Friends of Cudgen Nature Reserve Inc

Re: MODIFICATION TO KINGS FOREST APPROVAL NO. 08_0194 (MOD4)

Our group the Friends of Cudgen Nature Reserve submission to the proposed modification to Kings Forest approval follows.

**FENCING PLAN**

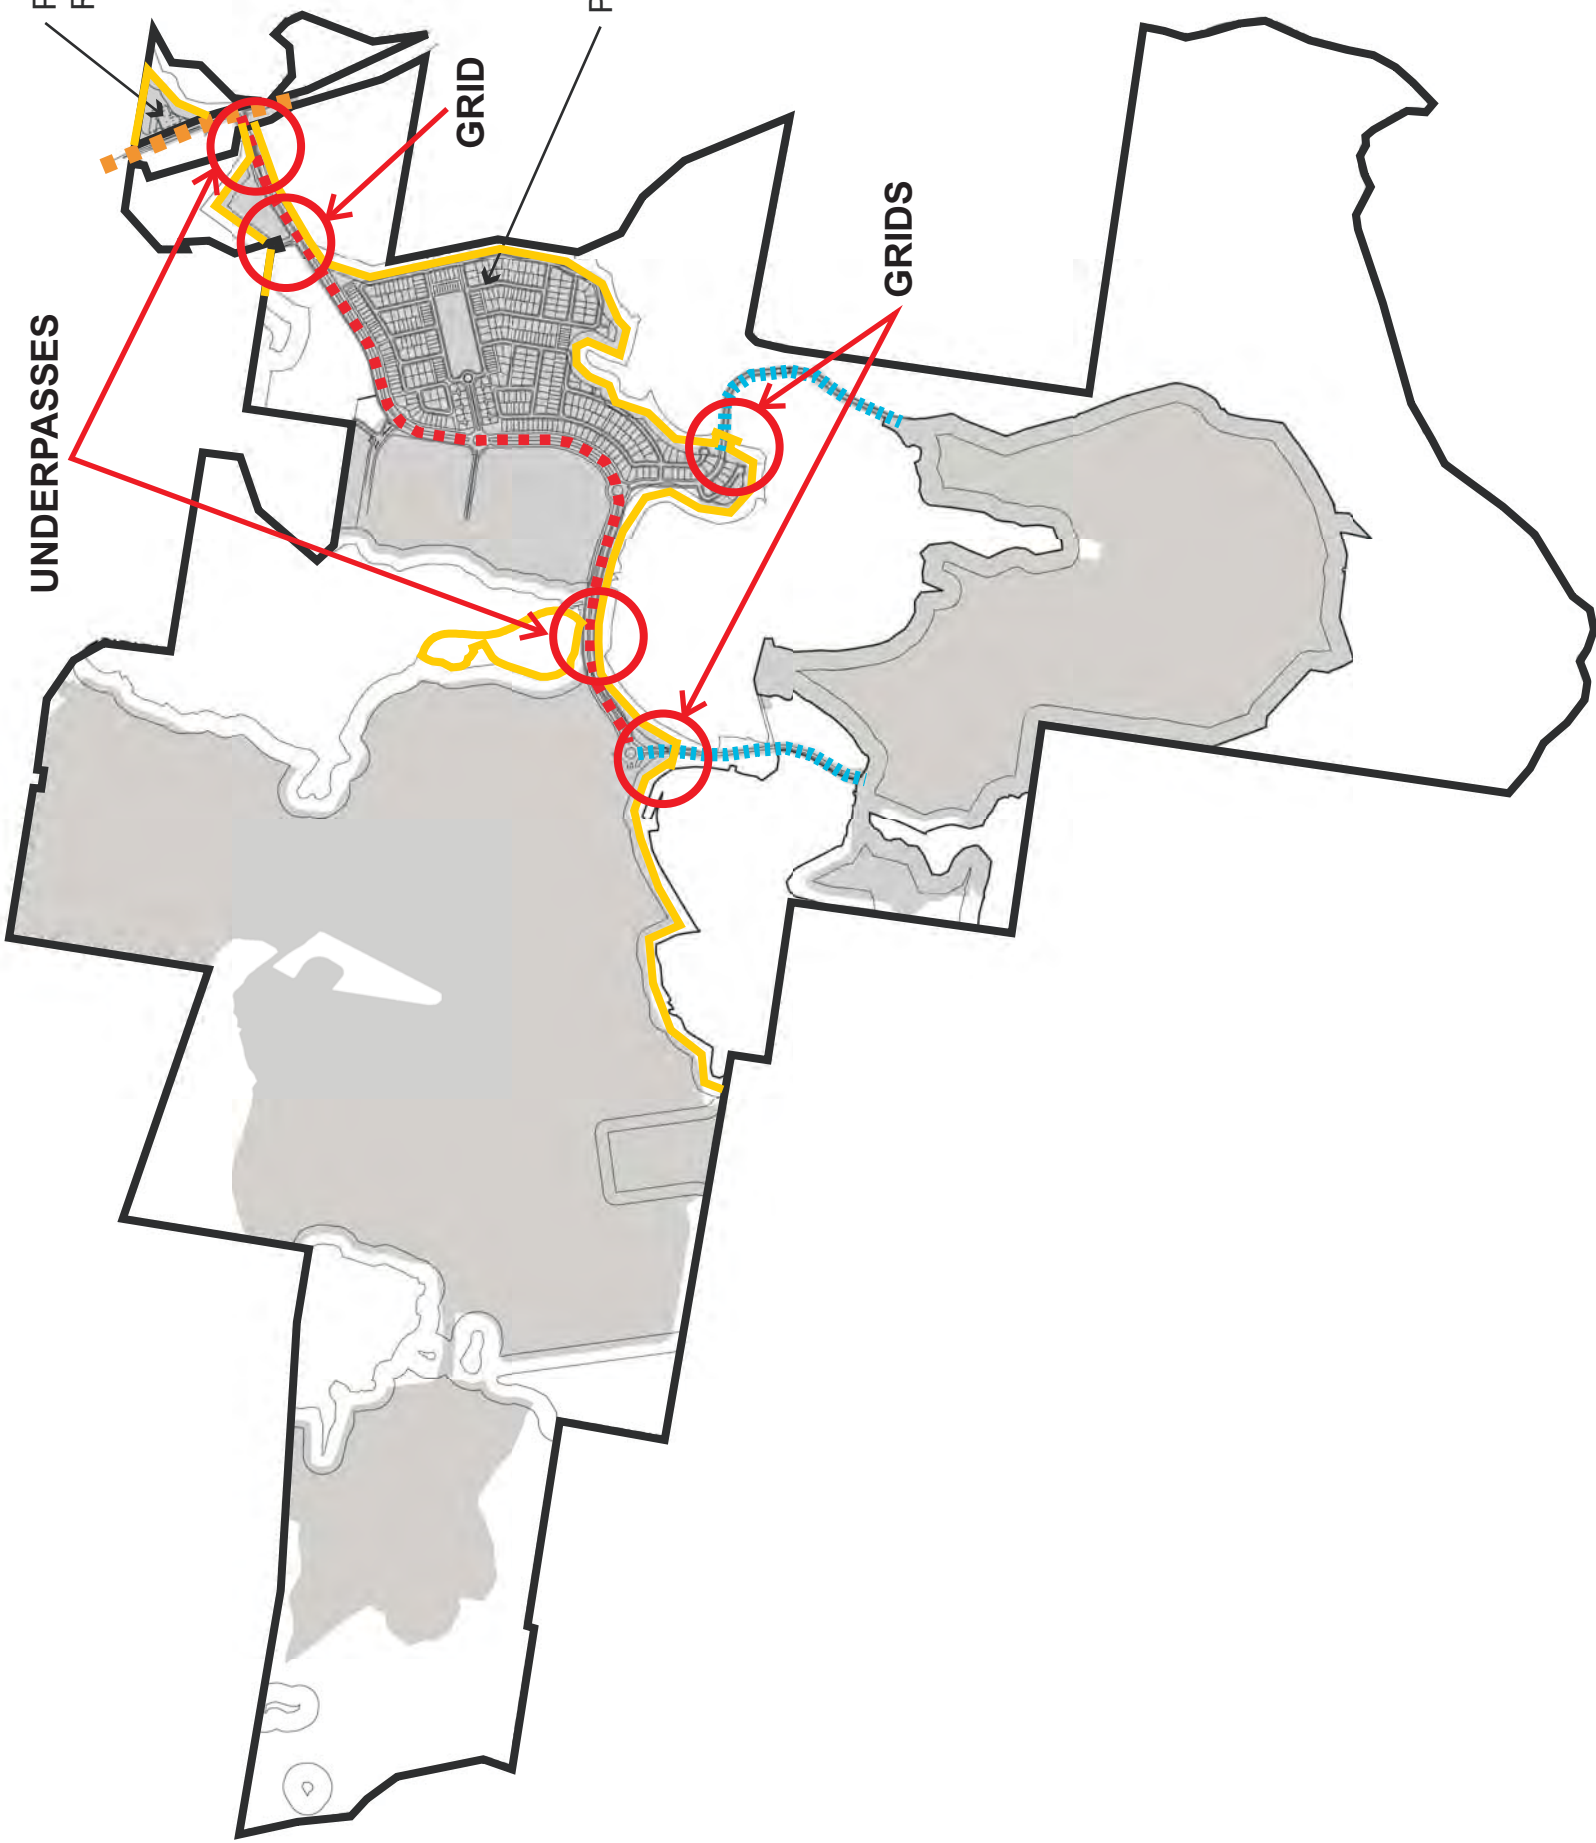
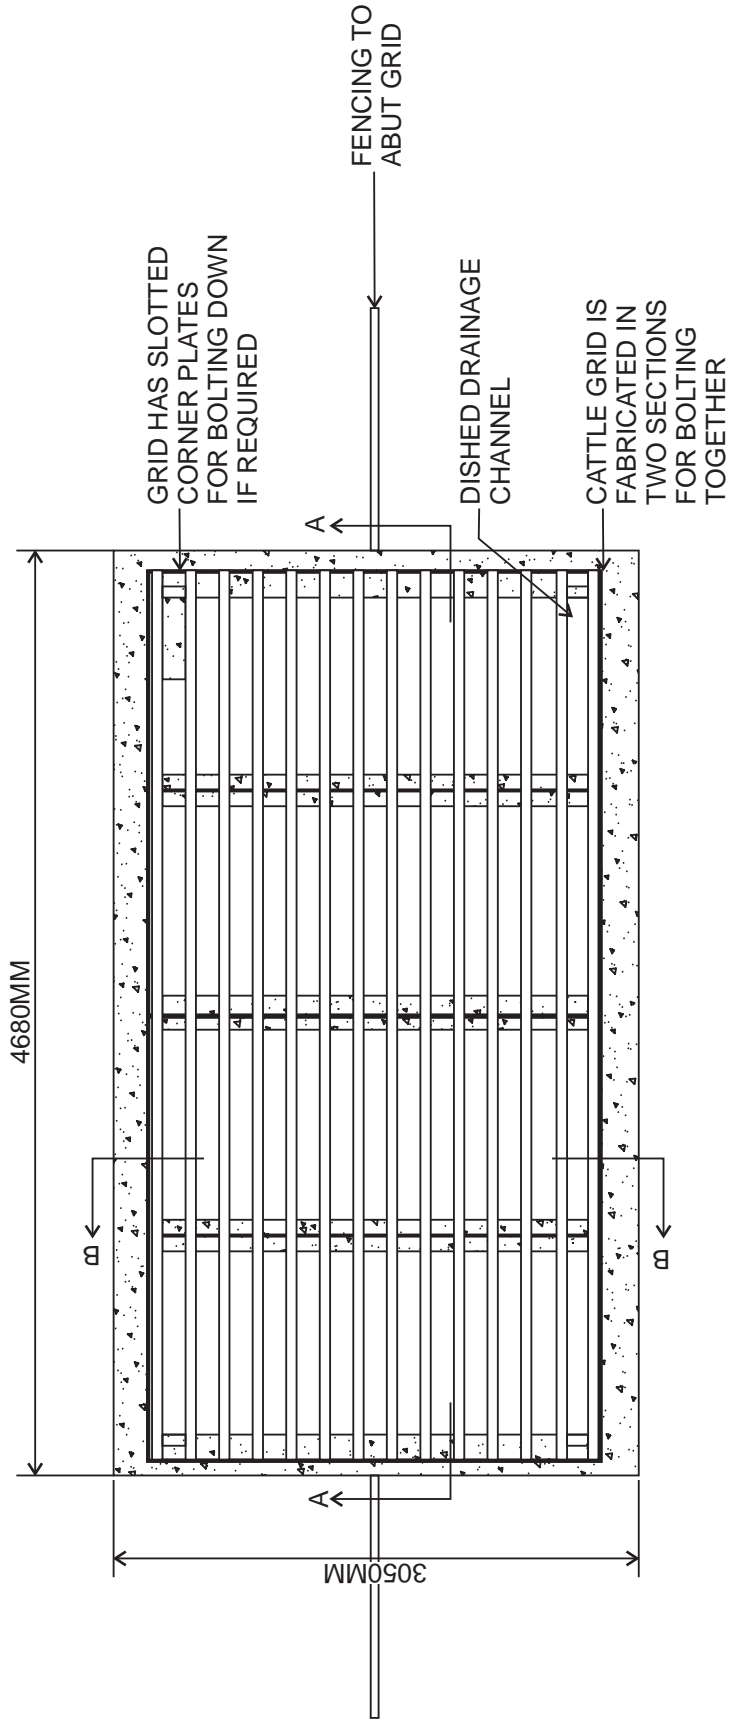
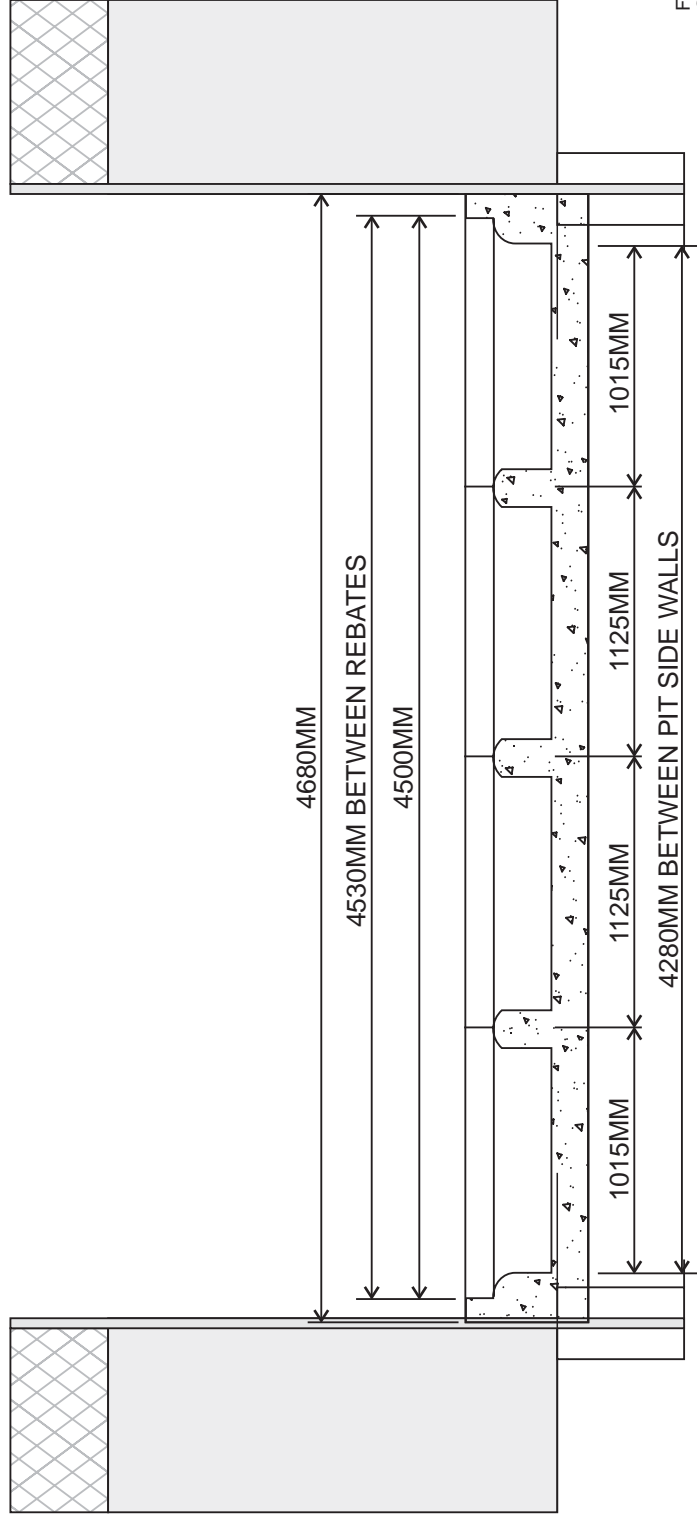
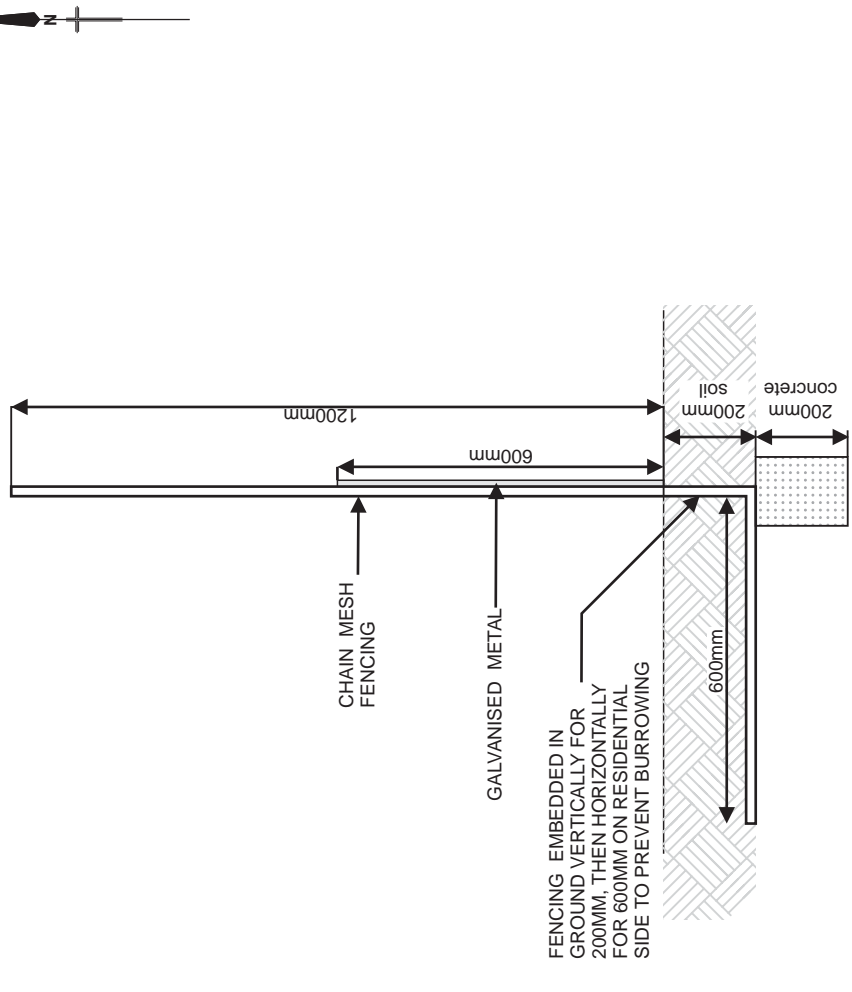
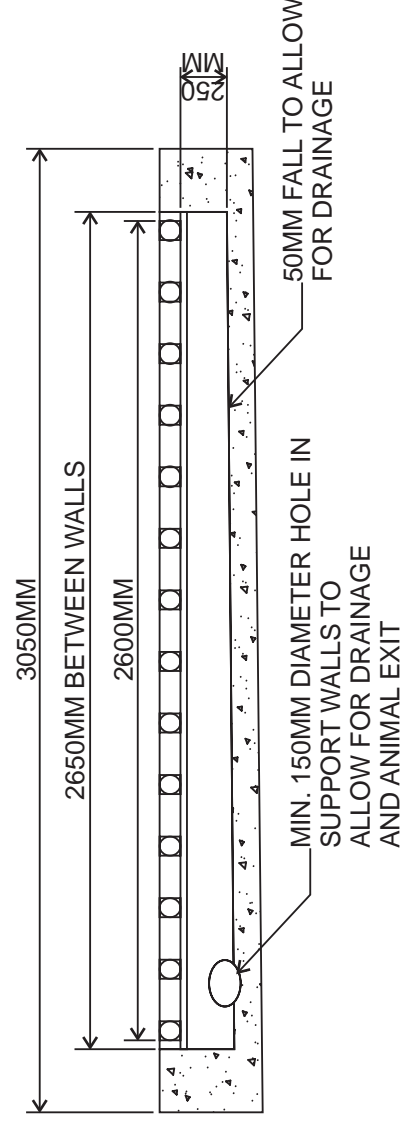
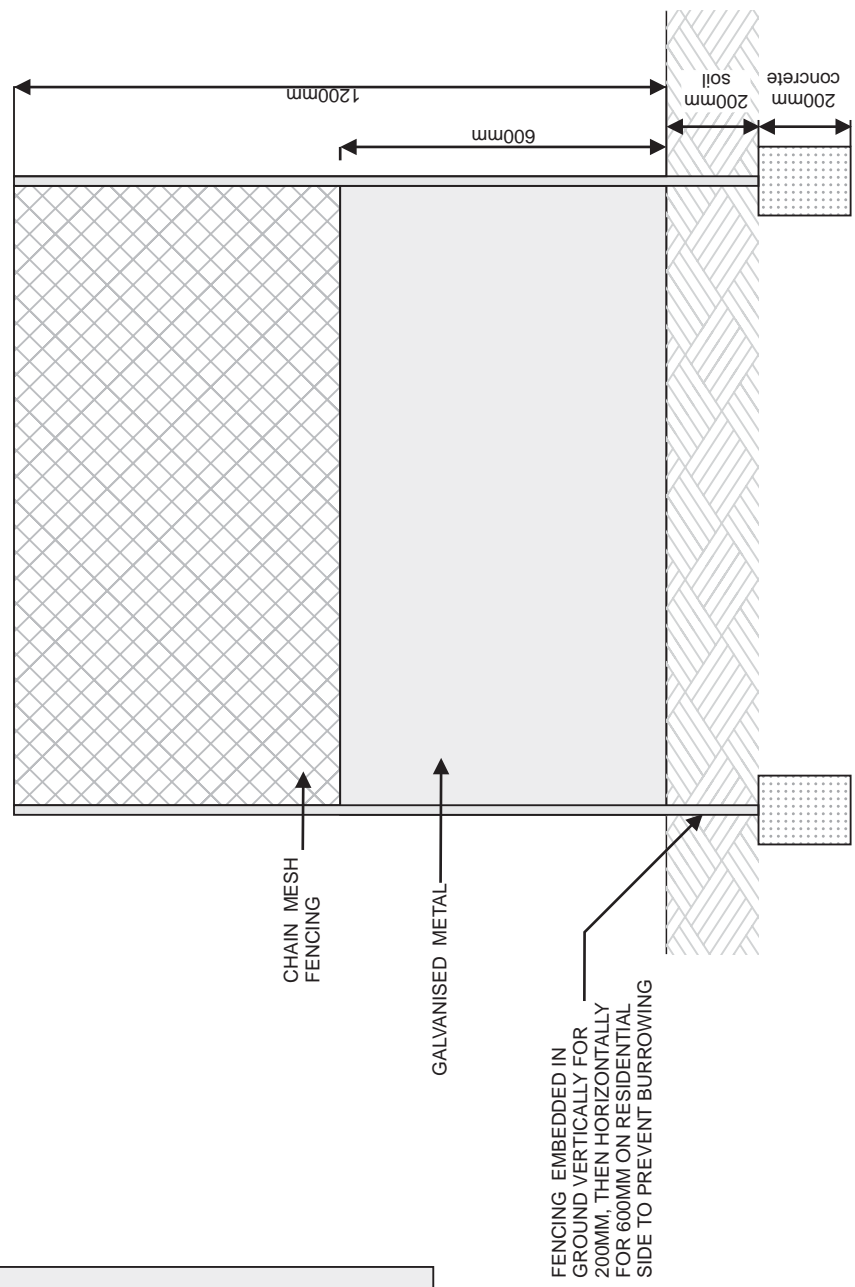
including removal of permanent koala fencing on roads in southern areas of the development and removal of fauna underpass associated with these roads. Grids are proposed in these areas to stop koalas entering the development site. Friends of Cudgen NR do not support these changes for the following reasons:

- The proponent is responsible for mitigating risks to koalas within the development site, particularly in light of listing of the Tweed Coast Koalas as an Endangered Population in 2016. If roads are not fenced on both sides where they pass through areas of koala habitat or environmental protection zones, there is a significant risk of koalas being hit, injured and killed by vehicles when they attempt to cross roads in these areas. This is not acceptable. These roads must be secured with permanent koala proof fencing on both sides and adequate fauna underpasses must be provided to ensure safe and also effective movement of koalas.
- Grids will not stop domestic dogs entering koala habitat and environmental areas. This means koalas in these areas are at higher risk of attack from dogs, which is also not acceptable.
